City of Portland, Maine - Building or Use Permit Application
 389 Congress Street, 04101 Tel: (207) 874-8703, Fax: (207) 874-8716

Permit No: 06-1597	Issue Date:	CBL: 397 D008001
------------------------------	--------------------	----------------------------

Past Use: Single Family	Proposed Use: Single Family remove existing deck and create a 14 x 24 4 season room	Permit Fee: \$420.00	Cost of Work: \$39,150.00	CEO District: 5
Proposed Project Description: remove existing deck and create a 14 x 24 4 season room		FIRE DEPT: <input type="checkbox"/> Approved <input type="checkbox"/> Denied	INSPECTION: Use Group: Type	
		Signature:	Signature:	
PEDESTRIAN ACTIVITIES DISTRICT (P.A.D.)				
Action <input type="checkbox"/> Approved <input type="checkbox"/> Approved w/Condition <input type="checkbox"/> Denied				
		Signature:	Date:

Plot Plan

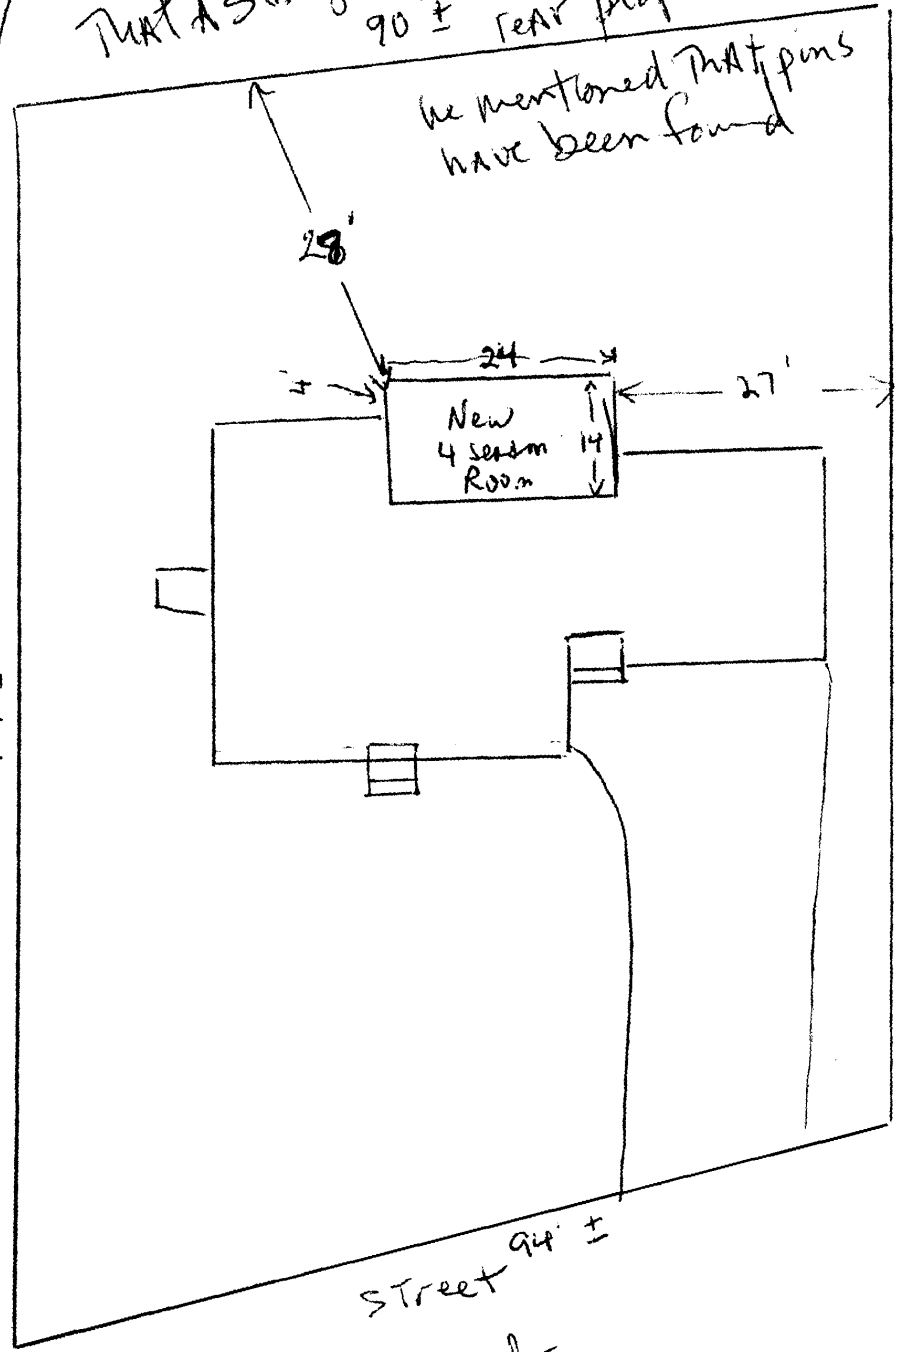
10/31/2006-mes: spoke with the contractor Norman LeBlanc concerning the rear setback. He thought that the 27' was conservative and that the pins were present in the back. I told him that at least 25' rear setback was the minimum required. He confirmed at least 25'.
